**SYDNEY OLYMPIC PARK AUTHORITY
DESIGN REVIEW PANEL
ADVICE SHEET**

Project	3.3 site 43/44, 2 Australia Avenue
Presentation / Review Date	24 th May 2012
Panel Present	Peter Poulet (Chair) Peter Webber Peter Mould Darlene van der Breggen
COI Declaration	nil
Also Present	Darren Troy (SOPA)
Presenters	Darlene van der Breggen
Documents made available	PP presentation
Inherited decisions	
Previous relevant SOPA Advice	17 th November 2011, 19 th April 2012
General Observations/ Overall Comment	<p>The proponent's recently revised design was tabled for information and discussion.</p> <p>The previously submitted design has been reviewed to incorporate the car park entry ramp into the stage 1 building footprint.</p> <p>The DRP was pleased with the resolution of the car park entry and loading dock entry problem.</p> <p>The DRP made some further suggestions in relation to the resulting street frontages.</p>
Positives	<p>The DRP supported:</p> <ul style="list-style-type: none"> ▪ relocation of the car park entry ramp into the building footprint. ▪ Use of future retail to screen the ramp walls and activate the future through site link (stage 2 link). ▪ Management strategies to limit the size of d

drawing
MASTERPLAN - TYPICAL
BASEMENT

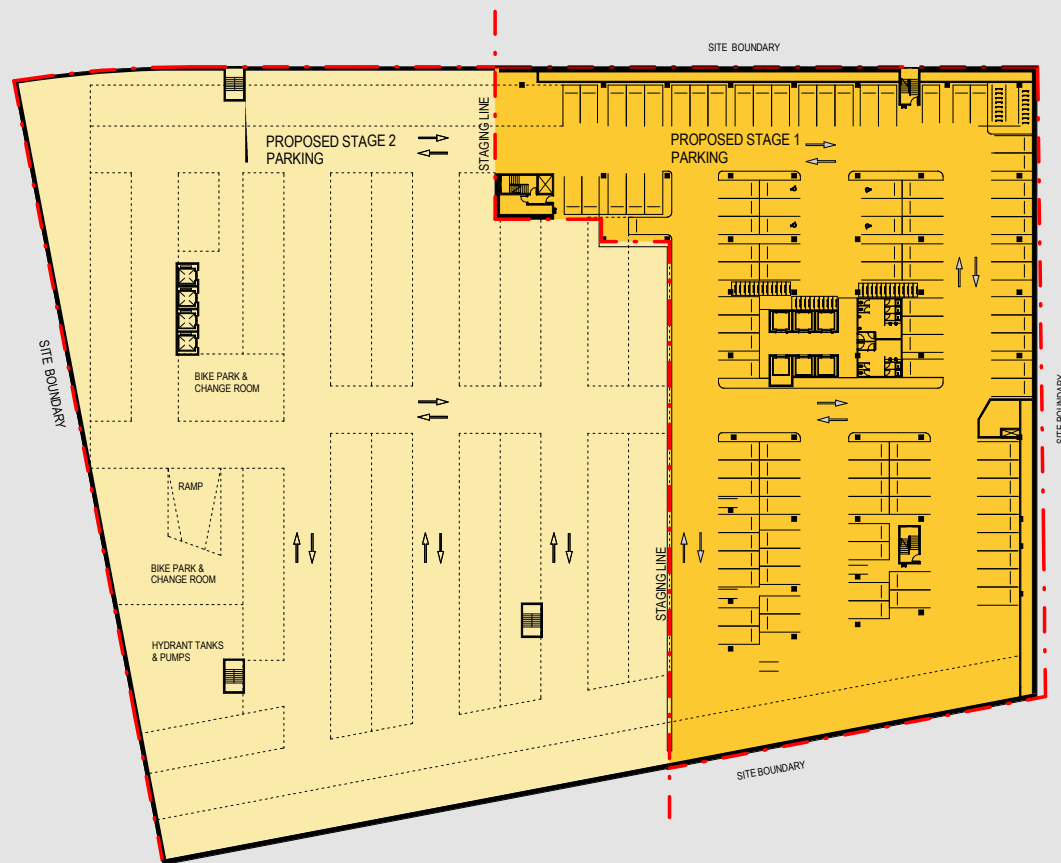
Issues	<p>The DRP had the following concerns:</p> <ul style="list-style-type: none"> ▪ Both vehicle entry ramps are now more exposed and will present 'black holes' in the public domain – consider extending the stage 2/3 podium to enclose both driveways. ▪ Width of the Stage 2/3 through site link is too narrow to adequately frame the view of the existing fig, as proposed in the competition submission - consider widening to 9m at least. ▪ Transparency of retail frontages on Australia Ave. ▪ Solar protection of retail frontages on Australia Ave – consider awnings or other shading device.
Matters for consideration	The DRP recommends that the above issues be

<p>addressed, particularly in relation to the through site link and exposure of the driveways.</p> <p>Proposed changes are to be reported at the next meeting and incorporated into the Preferred Project Report to Department of Planning.</p>
Recommended Supporting Action	<p>The DRP recommends that the transparency of the supermarket frontage be addressed as a condition of the retail fitout application. Suggested conditions include:</p> <ul style="list-style-type: none"> ▪ back of house functions be located away from the east wall, and, ▪ all or most of the east wall of the supermarket should be glazed to provide interest to the street.
Circulation of Advice	SOPA, proponents
